The British Horse Society

7 April 2022

Application no. 21/3475/OUT – Land adjacent to Lords Lane and SE of Hawkwell Farm, Bicester

Figure 4.5 Proposed Active Travel Routes

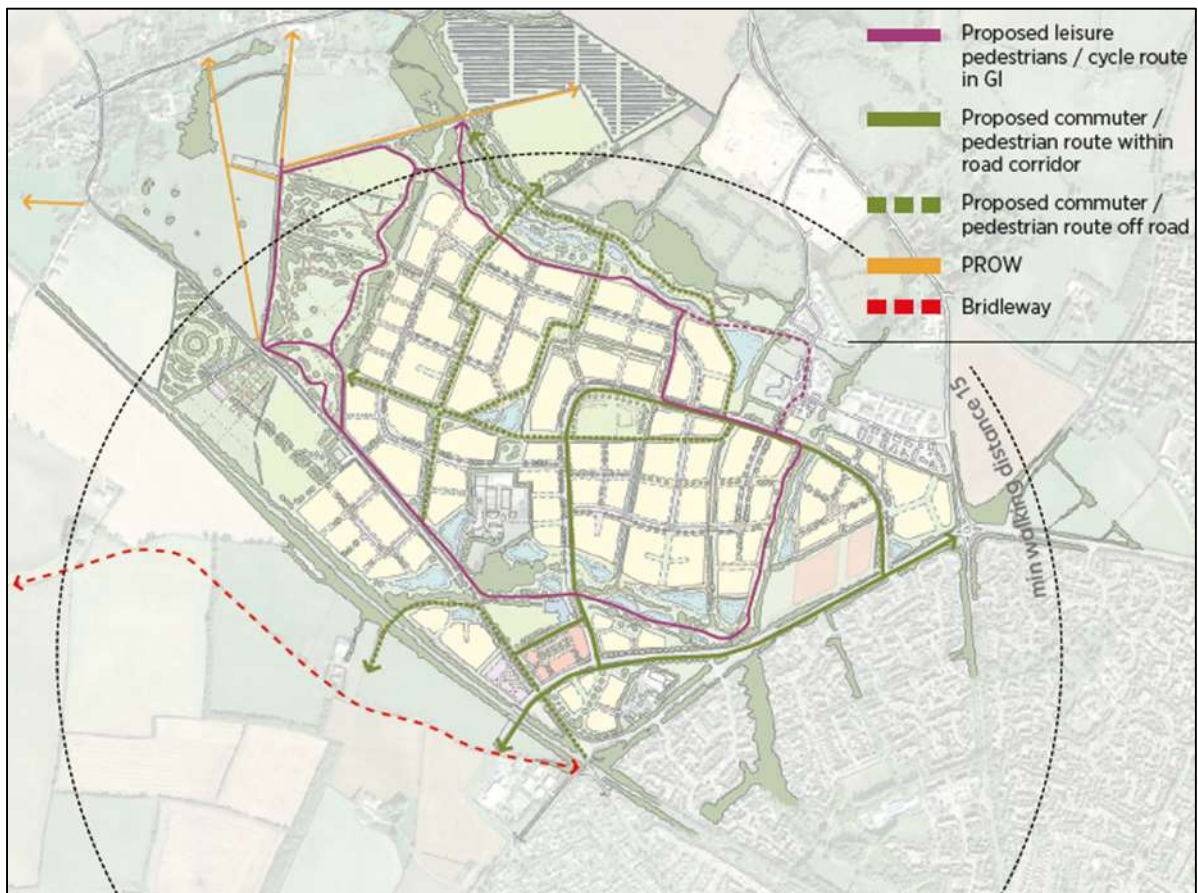
The Society considers therefore that the applicant should seek to mitigate this impact by including equestrians in some of the new off-road routes that are proposed for walkers and cyclists. If the potential leisure pedestrians/cycle route in GI identified in the DAS Walking & Cycling Strategy were to be dedicated as definitive bridleways, this would provide off-road recreational access for ALL vulnerable road users, including horse riders.

This is not currently reflected in the application, which in the Walking and Cycling Strategy proposes potential leisure routes for pedestrians and cyclists only.
